From: Cleaver, Elizabeth [REDACTED]
Sent: 08 July 2017 14:18
To: Planning.Responses
Cc: Planning SE; 'Tim Wall'
Subject: Highways England response: WA/44/17/OUT, Land East of Tye Lane, Walberton

Site: Land East of Tye Lane, Walberton

Planning Application No: WA/44/17/OUT

Highways England Ref: HAMIS 78375

T:\Projects\11000 Series Project Numbers\11324\ITB Land North of Walberton\Tech\Acad\Transport Drawings\Working Drawings\GA\ITB11324-GA-015 Rev B.dwg

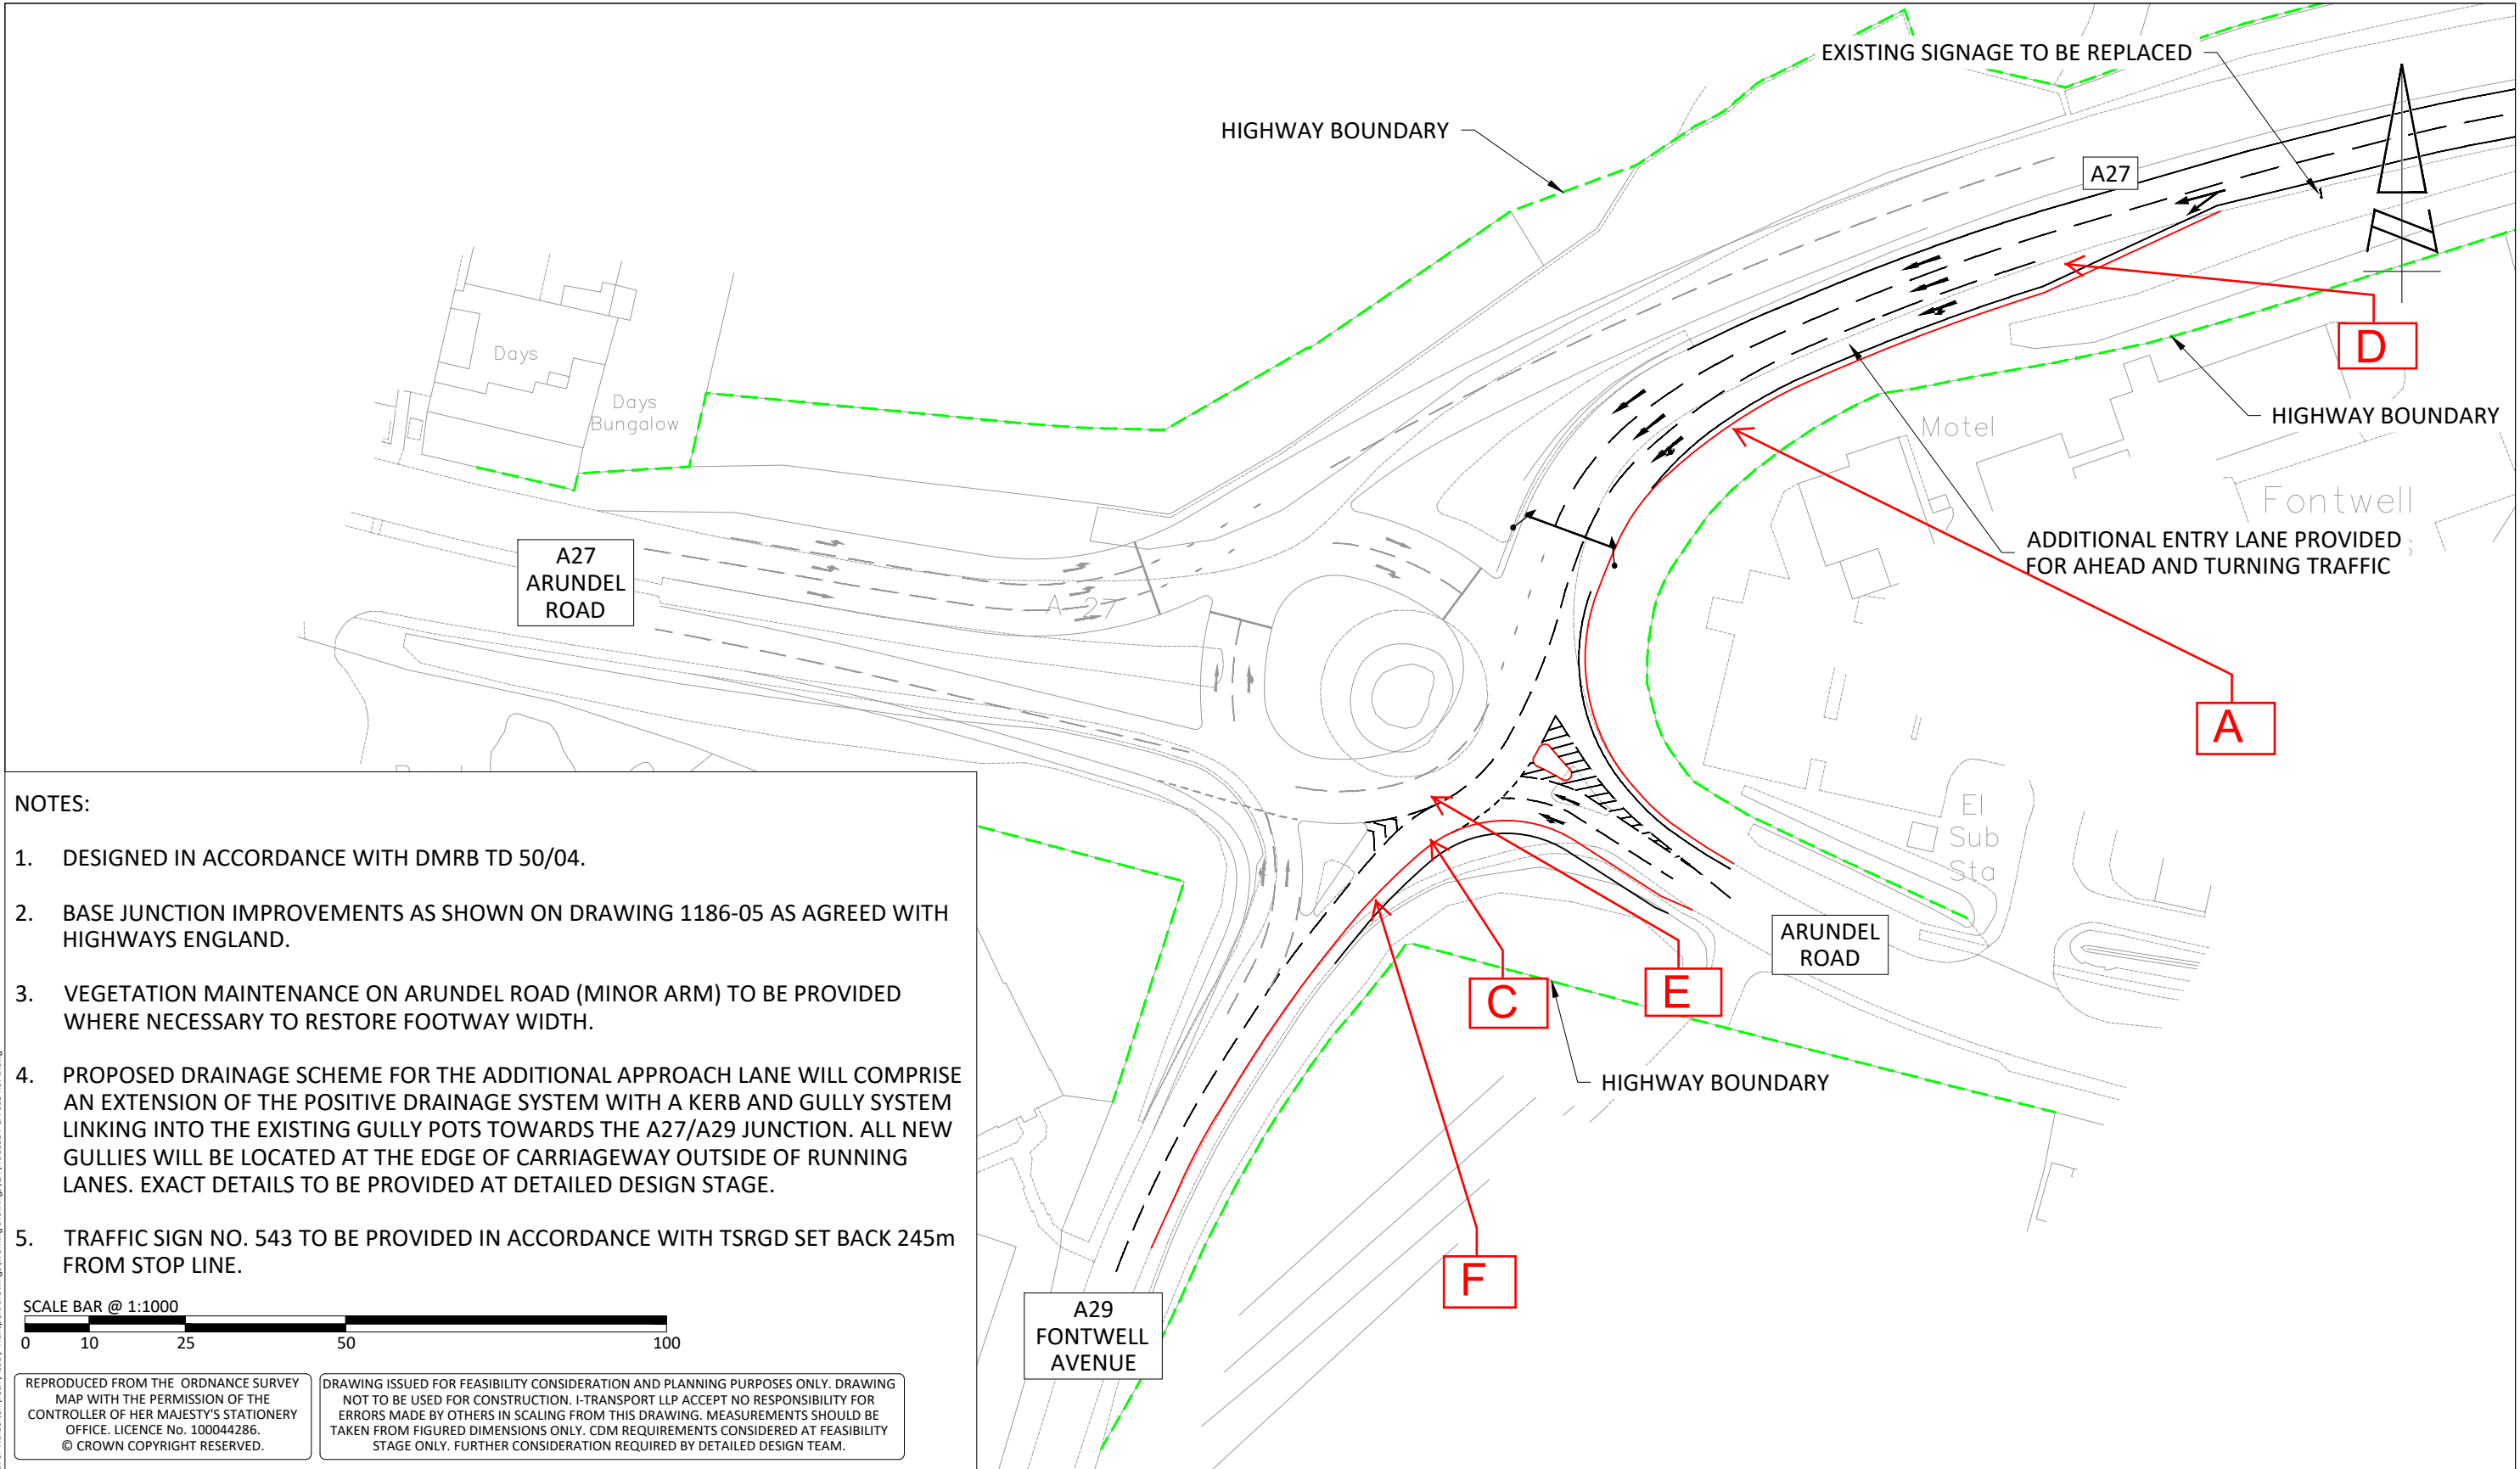
West LinSig Model (Additional Lane and Geometry Changes)

- A Directly Inputted Saturation Flow has been used – 1900. It should be noted that it is lower than the geometrically calculated saturation flow. It would be helpful if the applicant's consultant could provide justification for this Sat Flow.
- The lane length for Arm 3 (Arundel Road) Lane 1 is too long. The applicant's consultant has entered 60 PCUs as the length, but there is a mini roundabout about 130 metres from the roundabout so therefore the lane can not be 60 PCUs long.
